SUBMISSION REGARDING STATE SIGNIFICANT DEVELOPMENT
YORKTOWN PARADE AND FITZGERALD AVENUE, MAROUBRA –
AFFORDABLE HOUSING REDEVELOPMENT
PROJECT APPLICATION NUMBER: SSD-71454960

Gillian Thomas OAM

9 December 2024

EASTERN ELEVATION No. 38 YORKTOWN PARADE

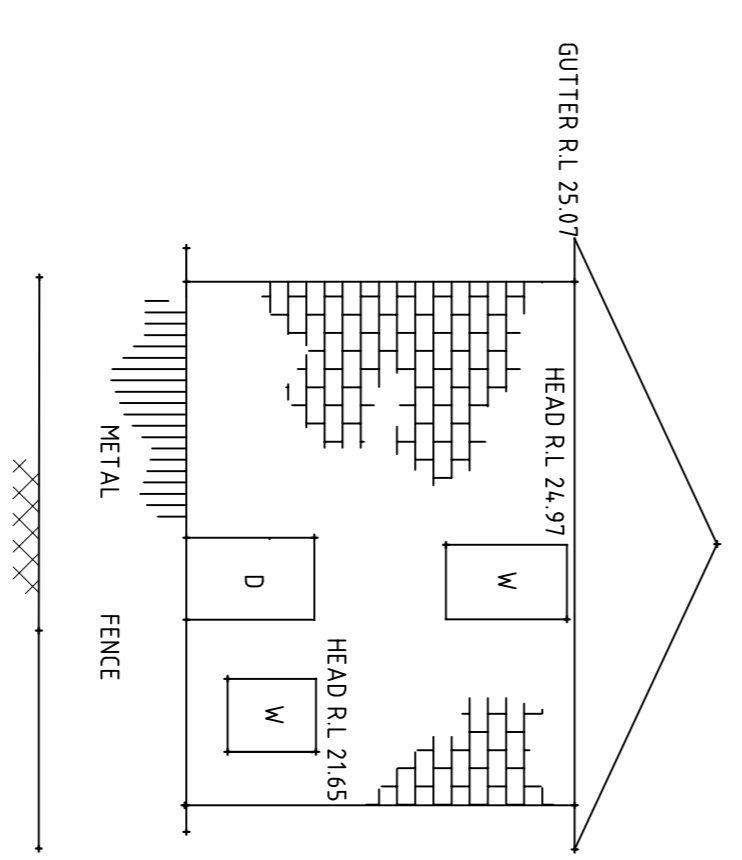
9. The Project will have severe impacts on its immediately adjacent property, 38 Yorktown Parade. This property is a single-storey brick home built in the 1950s, typical of the Coral Sea Park Estate and the original fabric of Yorktown Parade. Next door, at 40 Yorktown Parade, stands a matching single-storey brick house built at the same time. This is the house you see looking out the kitchen window of No. 38, together with a 70-year-old frangipanni tree basking in the sunlight. In the name of progress, it is proposed to demolish this neighbouring house, destroy the frangipanni, and replace them with a massive wall (the western side of Building 2A) nearly 14m high (including floor raising) and 28m long, close to the dividing fence (corrected setback minimum 2.7m, refer paragraphs 11 and 12 below). The view from the kitchen window will be masked by the huge wall, so close that not even a vestige of sky will be visible above it.

11. In November, when the EIS and associated documents were put on public exhibition, I was distressed to find that the minimum side setback (Building 2A) was not 5m but instead given as 2.88m. Perhaps there was a mistake? However, on investigation, the situation got even worse. Close inspection of the actual plans (EIS Appendix G) revealed that the architect does not calculate setbacks correctly according to the Standard: *"Setbacks are the horizontal distance between the relevant boundary and the building line. They are measured at 90 degrees from the boundary."* (NSW Department of Planning and Environment, *"Guide to Complying Development"*, August 2023). On the other hand, the architect calculates the setbacks at 90 degrees from the building line. This inflates the setback by a factor dependent upon the angle of the building line with respect to the boundary. The inflation could be large or it could be small. The serious consequence of my finding is that no setback measurements given in the EIS and associated documents can be assumed to be accurate – all must be validated by recalculating according to the Standard.

12. As noted, the EIS gives the minimum side setback of Building 2A as 2.88m, but after calculation according to the Standard, the true value is found to be 2.7m. At half the value I was quoted at the Community Drop-In Session, this was not the news I wanted to hear. According to the Randwick 2013 DCP, the minimum side setback control is 4m. It is therefore hard to reconcile the email advice I received from Homes NSW that “*ensuring appropriate boundary setbacks ... is woven through our conceptual design*”.

EIS Assertions (Section 7.2.3, Table 20)	My Responses
<p>The balcony of the proposed units at the south west of Building 2A are opposite a window at 38 Yorktown Parade that is presumed to be habitable space. The separation distance between the balconies and the window ranges is a minimum of 7.3m. This is within the 12m building separation required but is considered equitable as justified below.</p>	<p>The minimum separation distance of 7.3m between the Building 2A balconies and the 38 Yorktown Parade window is substantially less than the 12m building separation required. This is inequitable because the EIS does not provide any cogent or valid justification for this non-compliance, as set out below. The minimum separation distance involving screened windows is also non-compliant, as discussed above.</p>
<p>Setbacks to the boundary are approximately 3.39m. While this is short of distance of 4.5m either side of boundary its considered appropriate and equitable as follows:</p>	<p>The 3.39m setback is for upper floors only. According to the ground floor plan, the setback is 2.88m. The actual corrected setback is 2.7m (as discussed in paragraphs 11 and 12). This is considerably short of the distance 4.5m and is neither appropriate nor equitable, as follows:</p>
